TOWN AND COUNTRY PLANNING ACT 1990

FULL

Reference: H09-0800-20 **Date of Decision:** 12th November 2020
Applicant: Mr J Jones
The Denn
Wood Lane
Thurlby
Bourne
PE10 0HQ
Location: Redwood Lodge 96 Dog Drove North Holbeach Drove Spalding
Description: Erection of replacement bungalow

REPLACEMENT DWELLING 96 DOG DROVE NORTH HOLBEACH DROVE PE12 0SA	A1@SCALE SHOWN
	DRG: PL01B
	MR J JONES

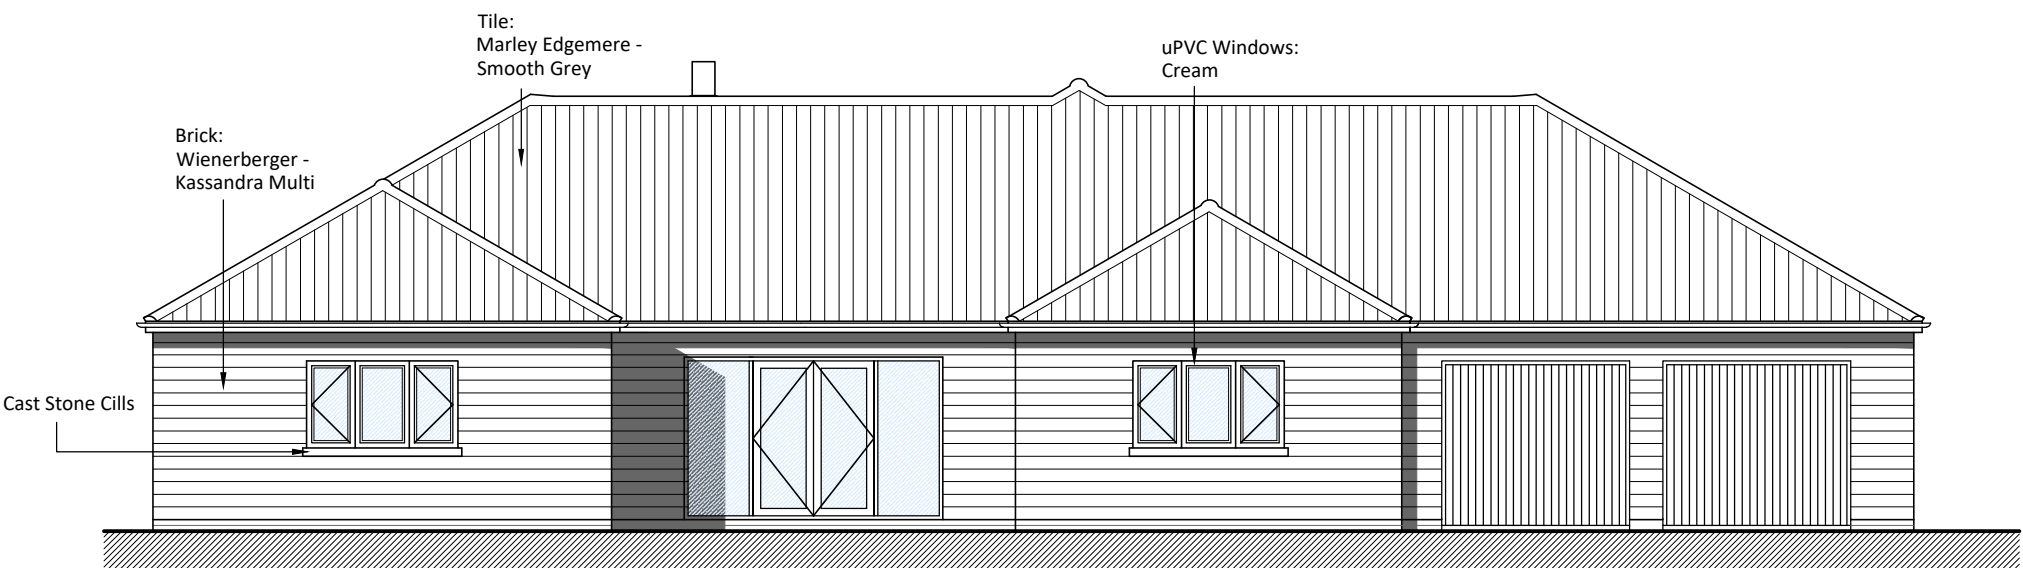
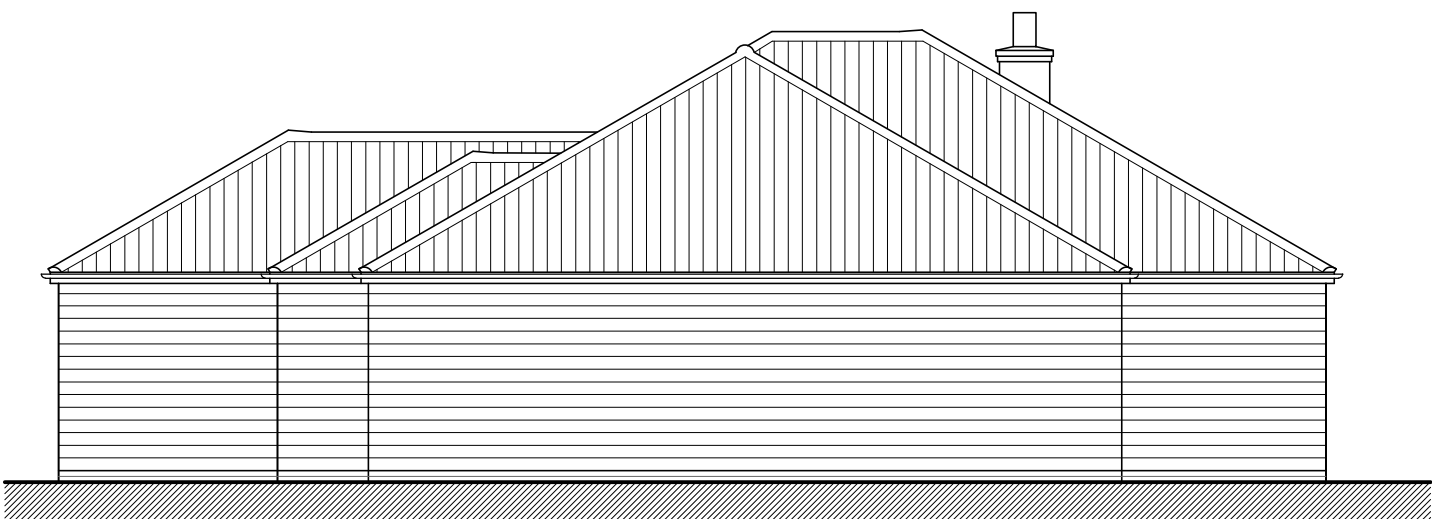
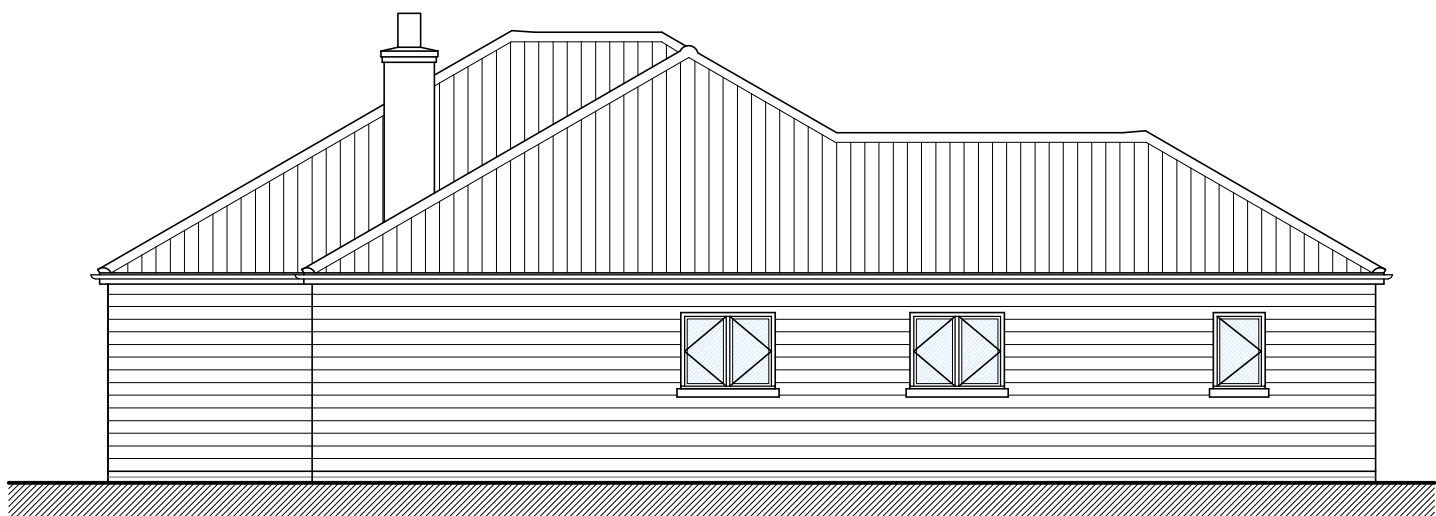
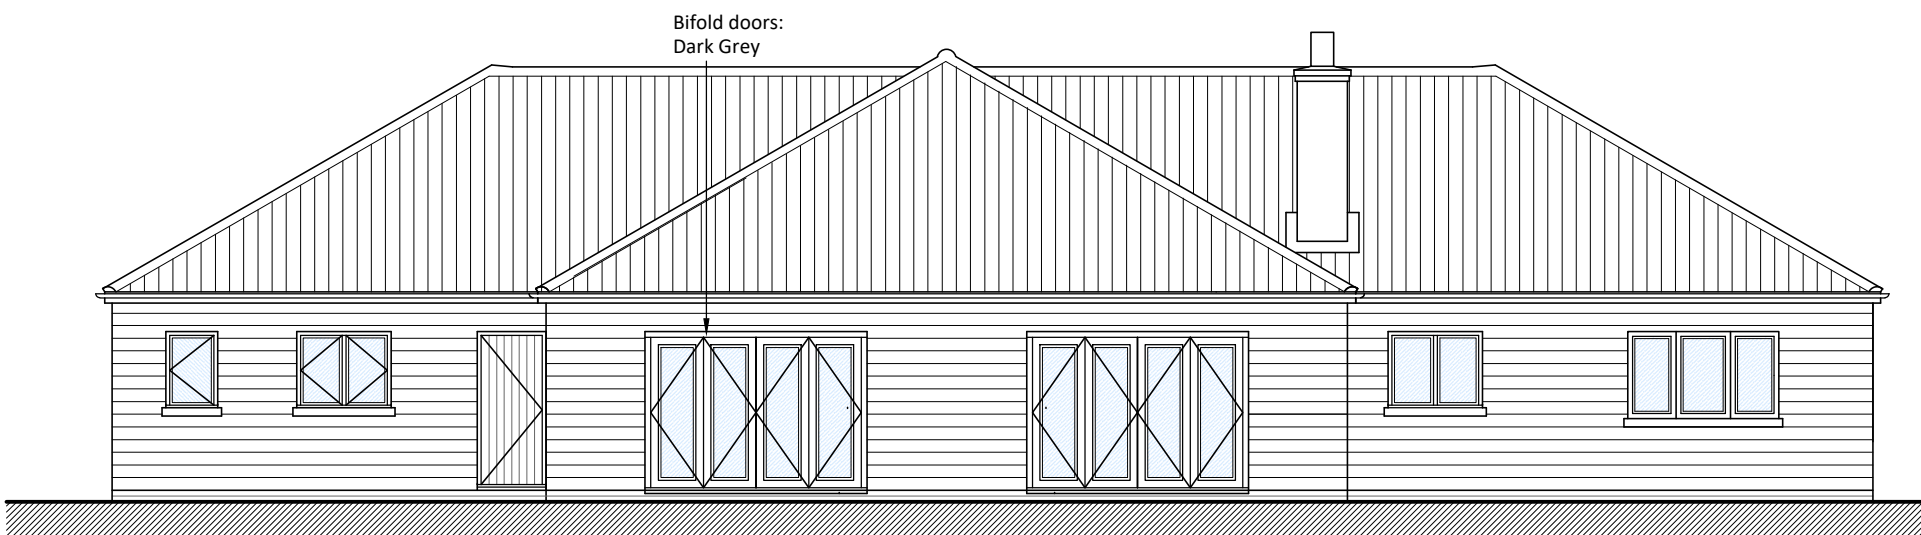
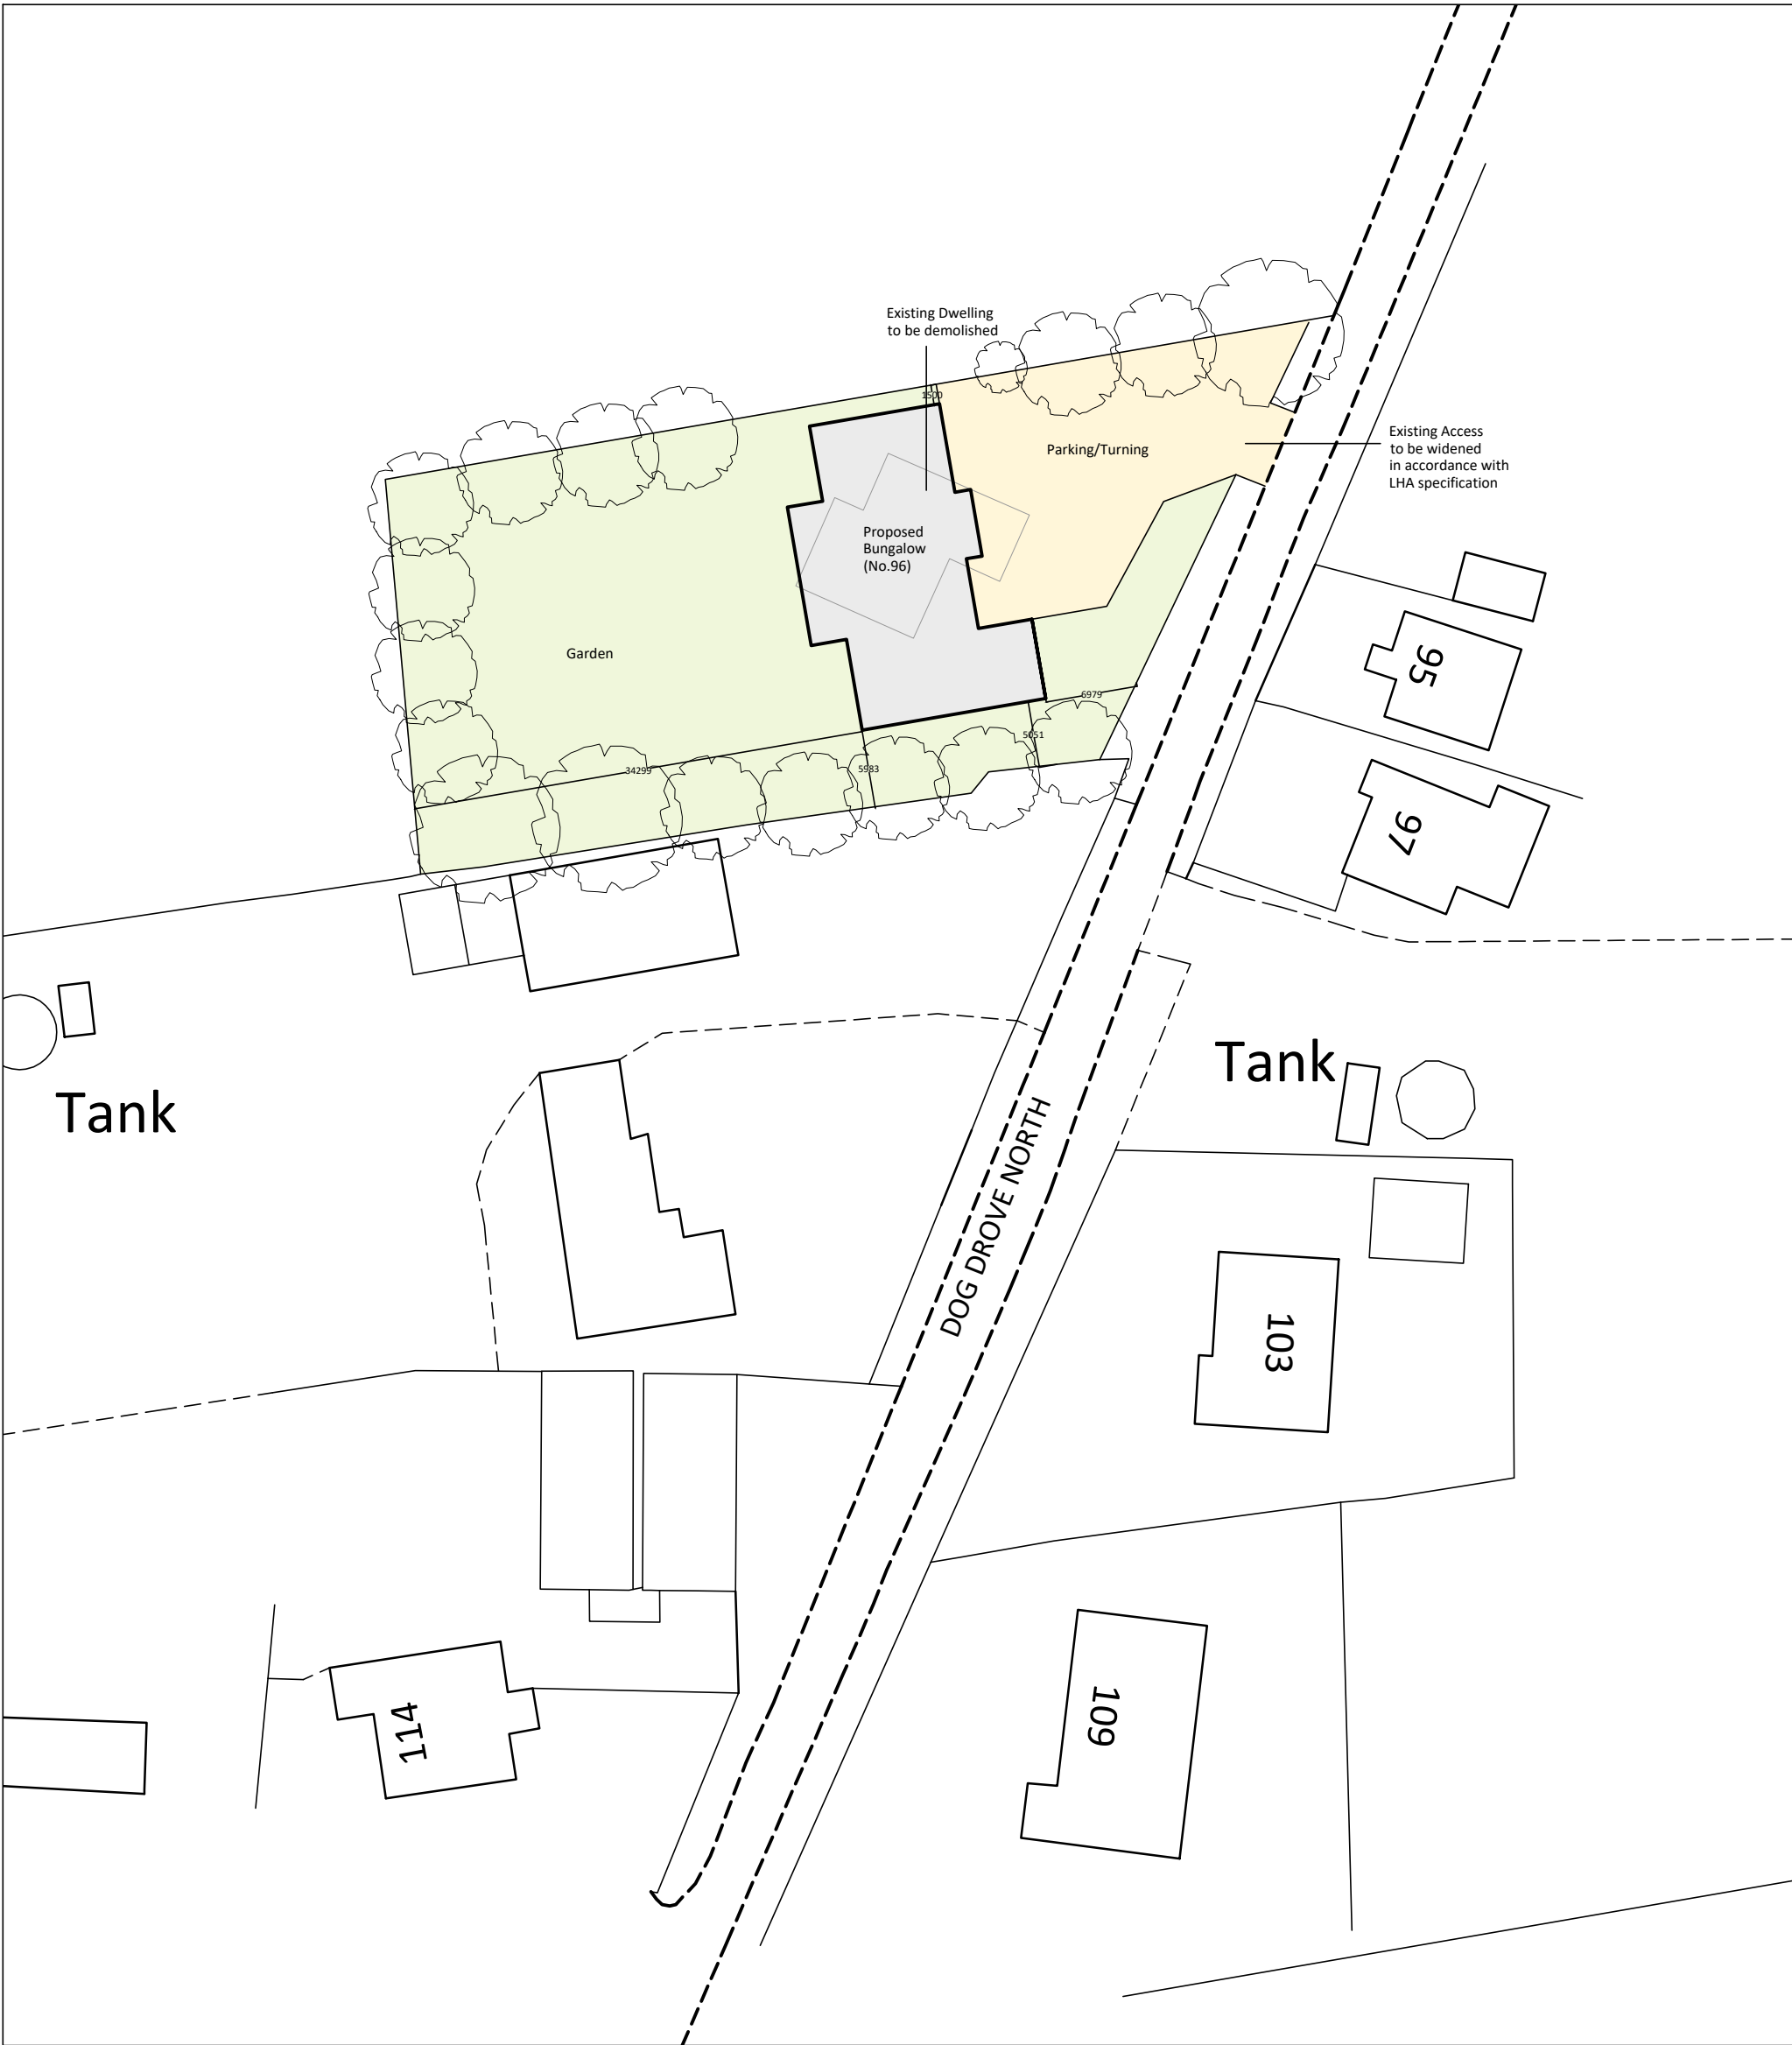
After assessing the proposals against the criteria above, it is concluded that the proposed development would not accord with criteria 3, 5 and 6.

No evidence has been provided to demonstrate that the existing bungalow is not capable of repair. In addition to that, whilst the replacement building would be positioned on a similar footprint to the original building, the new bungalow would no longer face south-east and no evidence of the benefits of the re-orientation has been provided. Last but not least, the proposed replacement building would be excessively larger than the original building as the floor area of the original dwelling would be exceeded by more than 40%. No evidence of exceptional quality or innovative features of the intended dwelling has been identified in order to justify such an increase in floor area.

The development clearly fails to comply with Policy 22 of South East Lincolnshire Local Plan (SELLP), 2019. It is acceptable on the grounds of residential amenity, car parking provision, highways safety and flood risk. However, the adverse impacts of granting permission for the development as submitted would significantly and demonstrably outweigh the benefits. The replacement dwelling itself has not been justified and the re-orientation and larger footprint of the new dwelling would harm the rural character of the wider area.
